**CITY OF ALBUQUERQUE
PLANNING DEPARTMENT**

DRB Comments

PROJECT # 1009988

RE: Lot 3, Block 4, Sandia Research Park

Sketch Plat for  
**Lost 3-A, 3-B and 3-C, Block 4  
 Sandia Research Park**

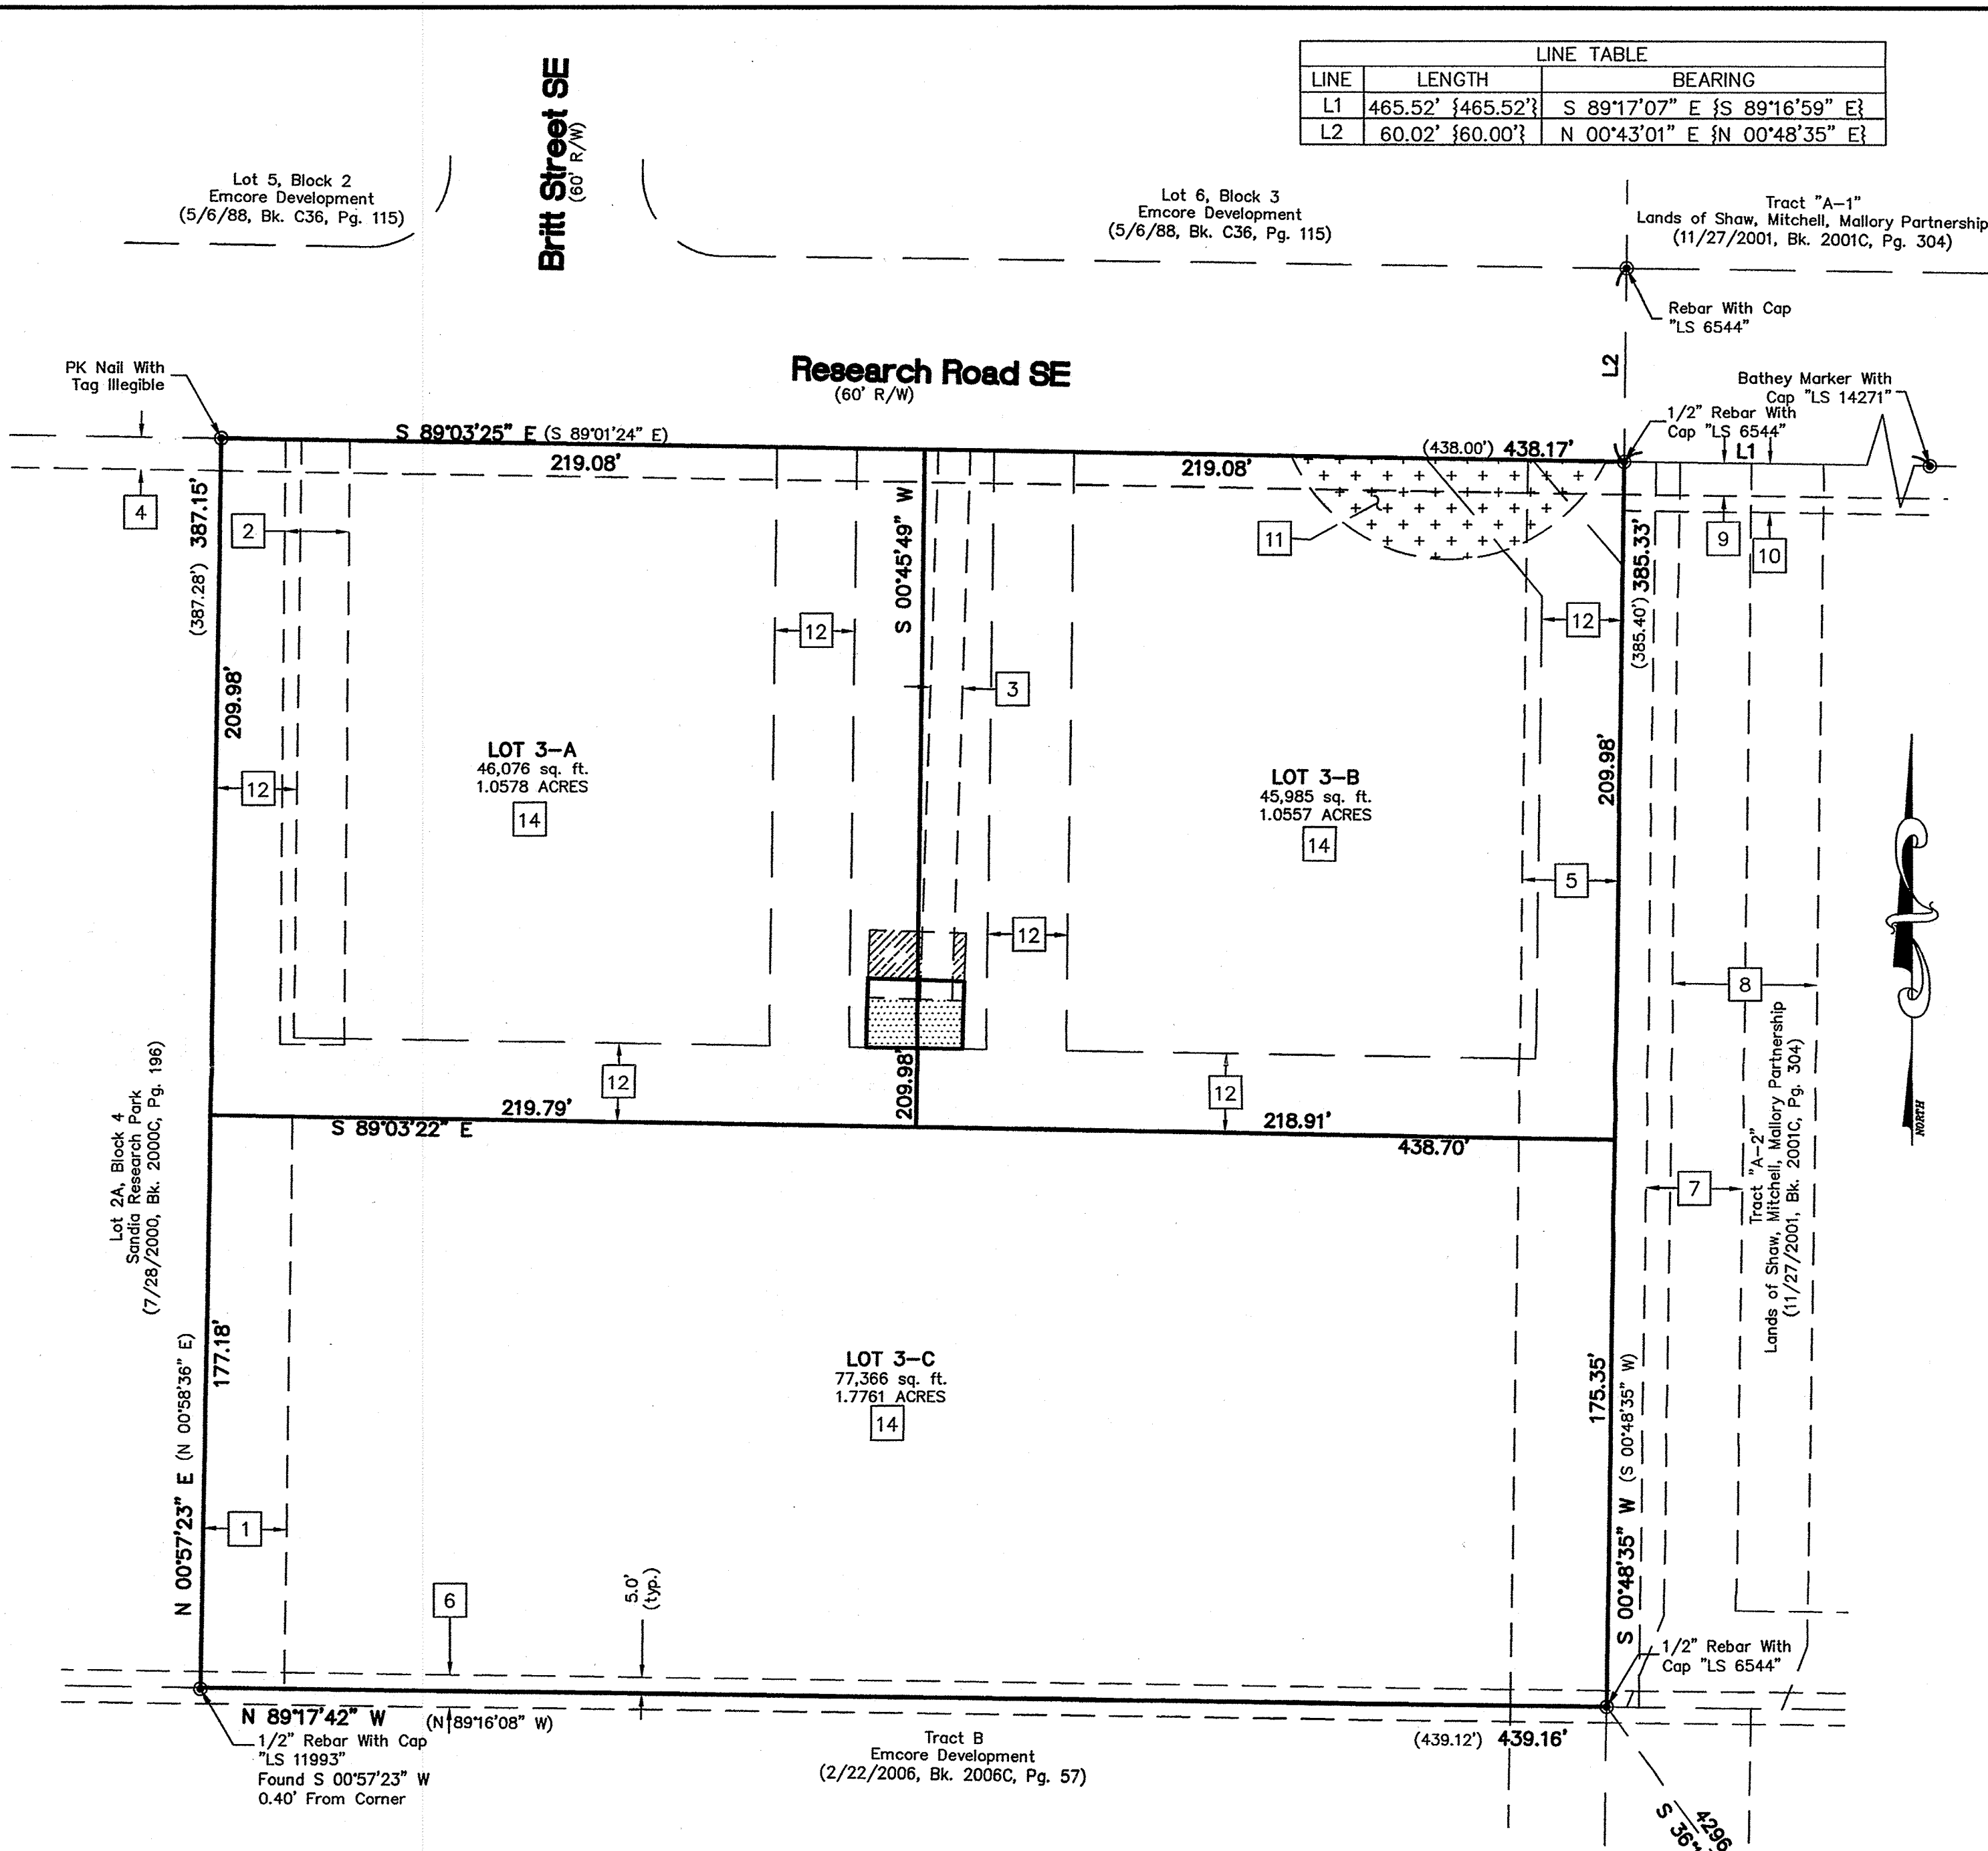
Parking calculations are needed to demonstrate that each proposed lot will meet its on-site parking requirements, or a Parking Variance will be required. An amended site plan is required, to show proposed lot lines.
